From: Lauren Wiltshire [REDACTED]
Sent: 24 May 2019 10:35
To: Simon Davis <Simon.Davis@arun.gov.uk>; Laura Gibbons <Laura.Gibbons@arun.gov.uk>
Subject: RE: Planning Consultation on FP/42/19/DOC

Engineers Comments Regarding Condition 7

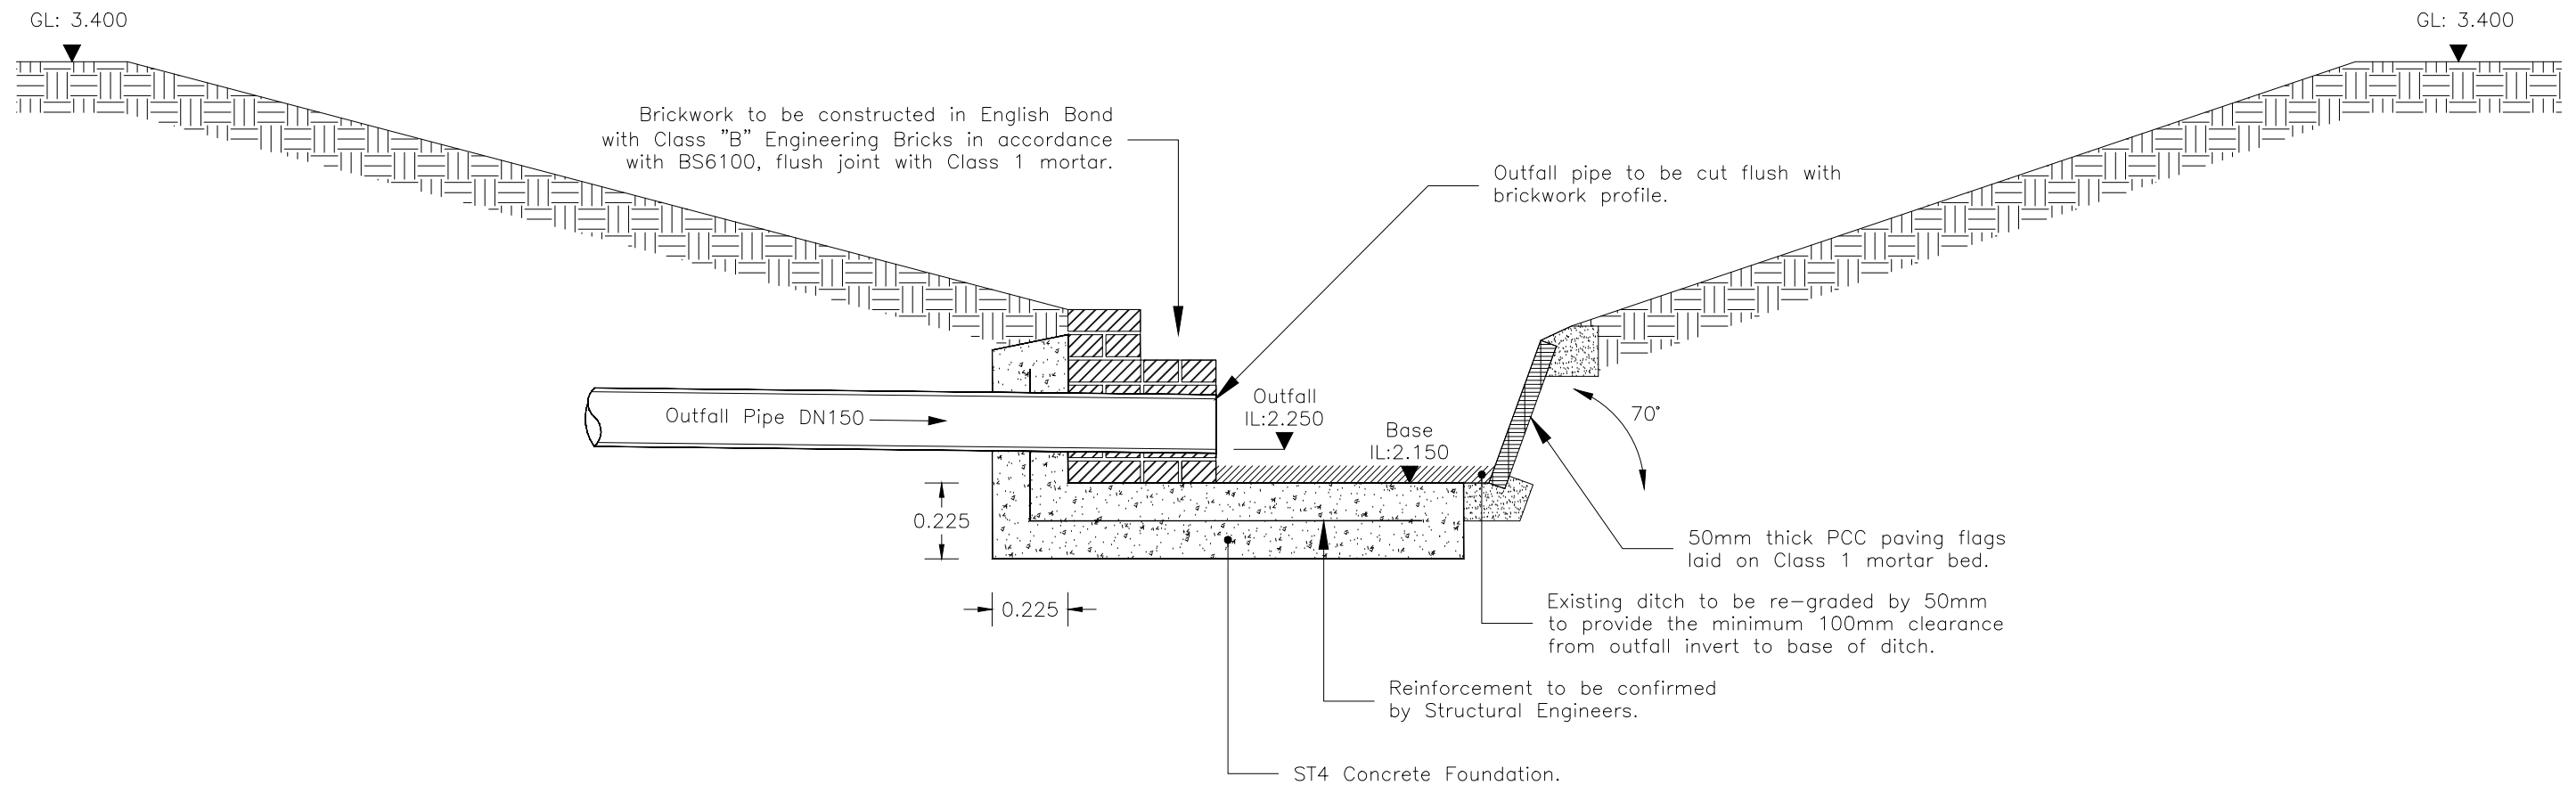
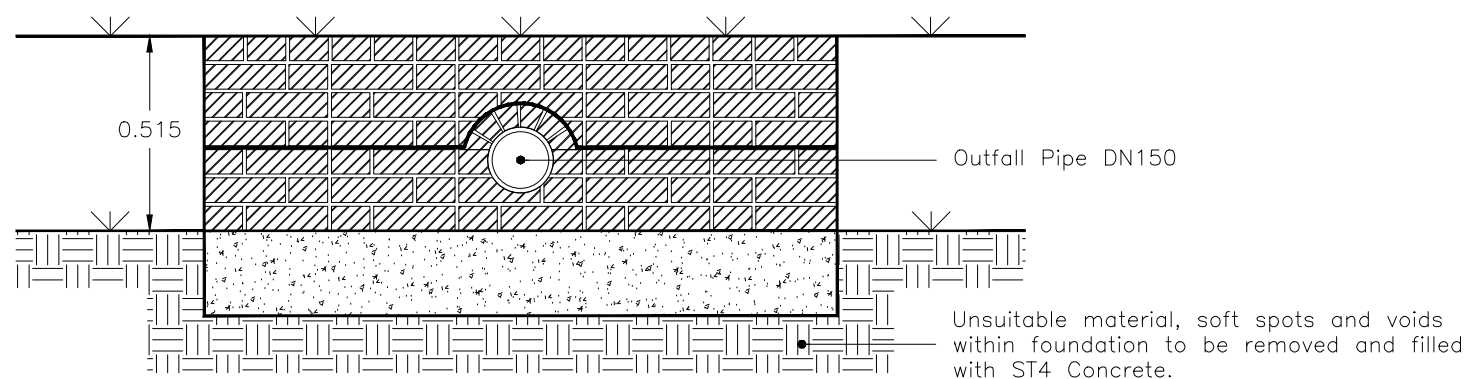
2. No construction detail drawings have been provided. Please provide construction detail drawings of manholes, catchpits, permeable paving, attenuation tank and hydrobrake.
Please refer to the following drawings:

- 5782:20 Outfall Details
 - 5782:21 Adoptable Drainage Details
 - 5782:22 Private Drainage Details
 - 5782:23 Construction DetailsThe above layouts demonstrate the required details.

Project: Wellers Close Hampshire Homes Group	
Drawing: Soft Landscaping Concept	
Date: May 2018	Drawn by: JA
Scale: 1:200 @ A1	Revision: -

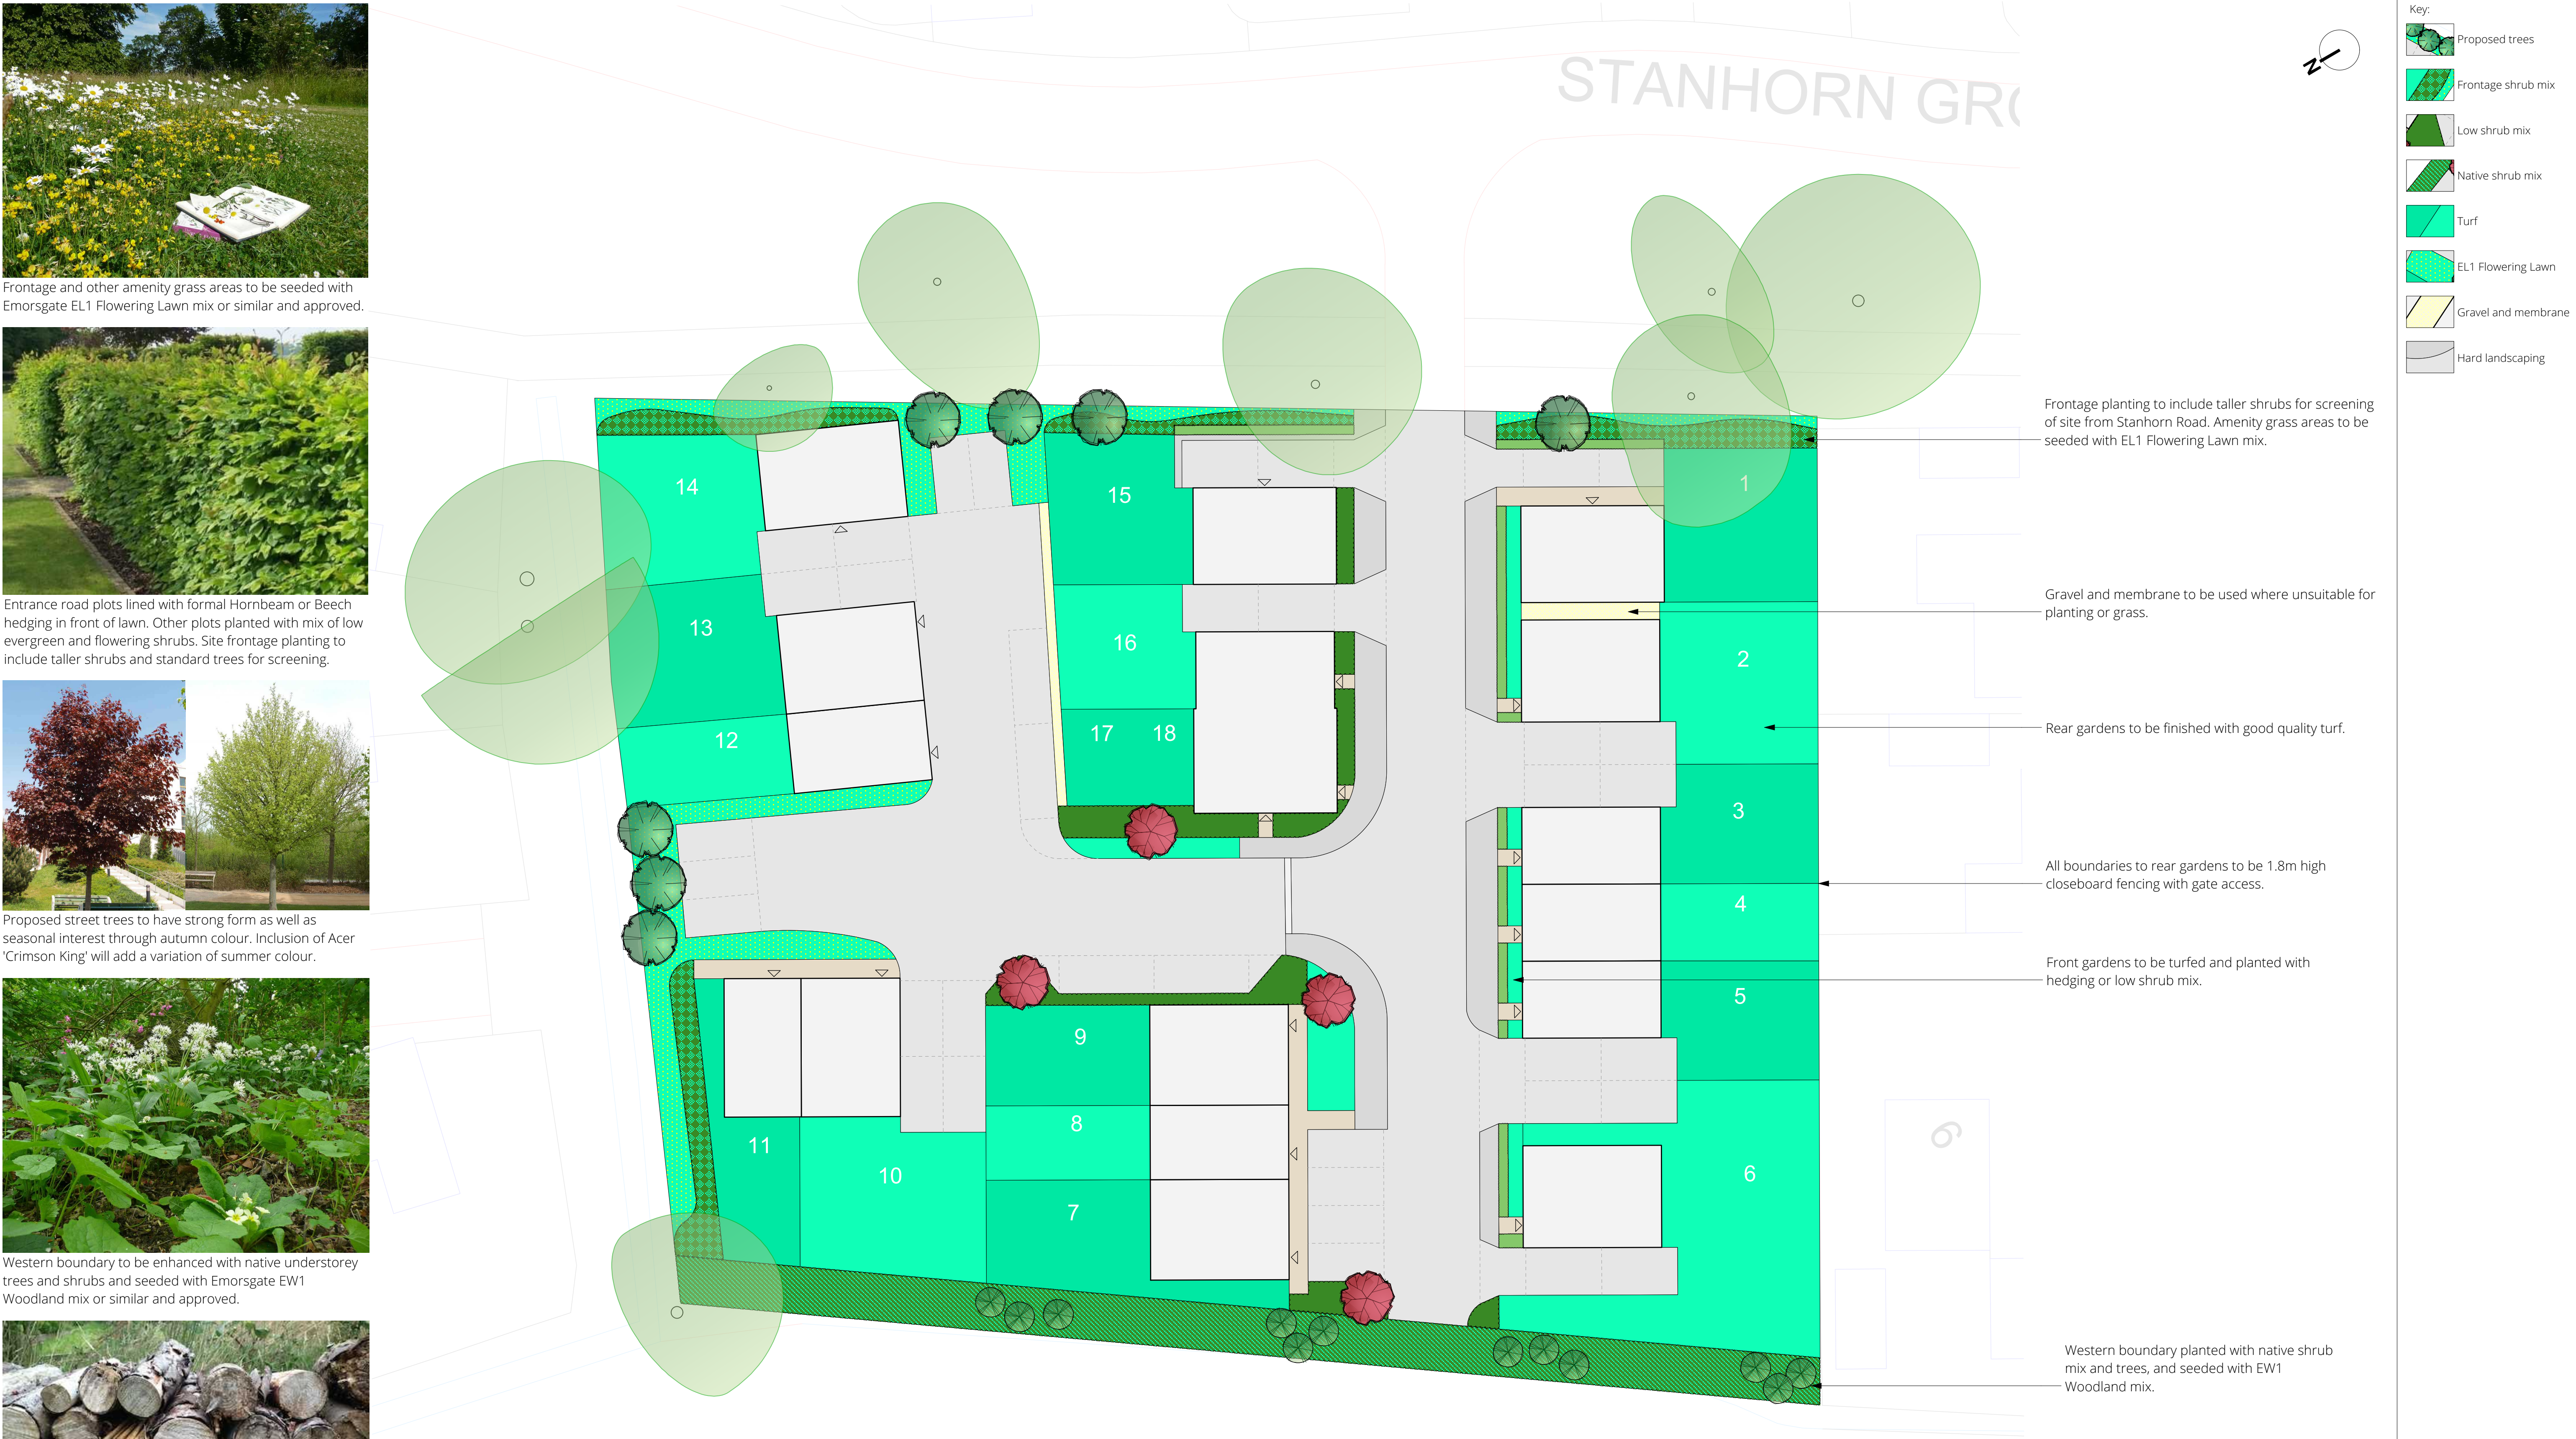
3. There is conflict between the landscaping proposals and the drainage proposals. Trees must not be located on or near attenuation tanks. Please revise the landscaping proposals.
Consideration has been made, nevertheless the proposed attenuation tank is located within the carriageway. A note has been added to our engineering layout stating no trees should be planted within close proximity of to the proposed attenuation tank.

Rev.	Date	Note	Author	Checked
A	11/06/19	De-mountable fence indicated to rear of Plots 12 - 14	RR	JP

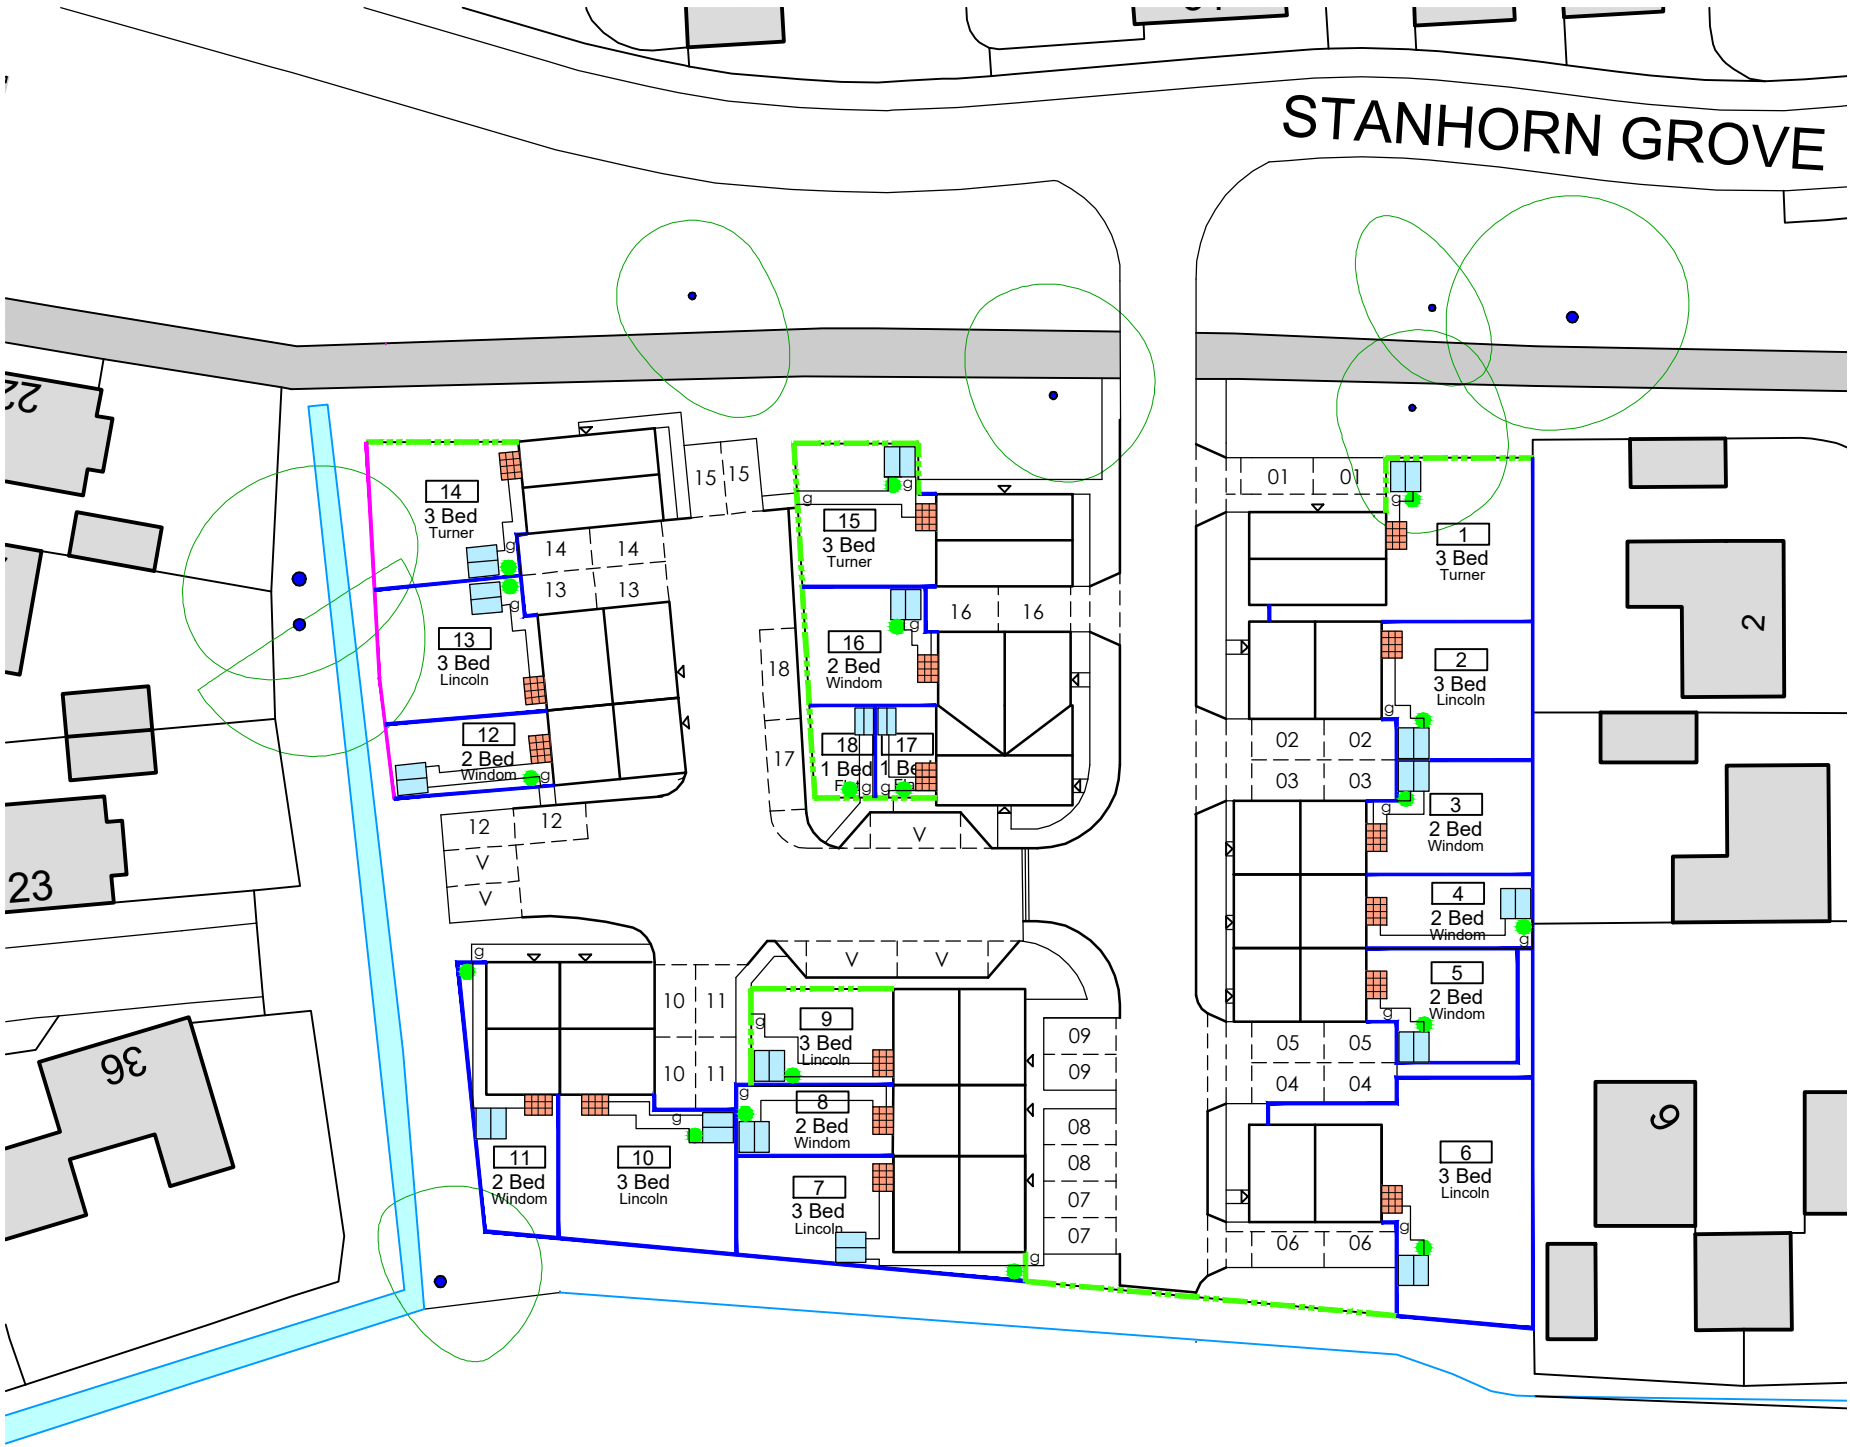
Proposed property boundaries for plots 12-14 need to be amended to allow access to the watercourse. 3m easement is required from any building, fence or wall and the top of bank of an ordinary watercourse.

In regards to the easement location between the two fences there is a 1.2m gap, the adjacent properties backing onto the ditch have a hard boundary onto the bank whereas we do have the majority buffer.
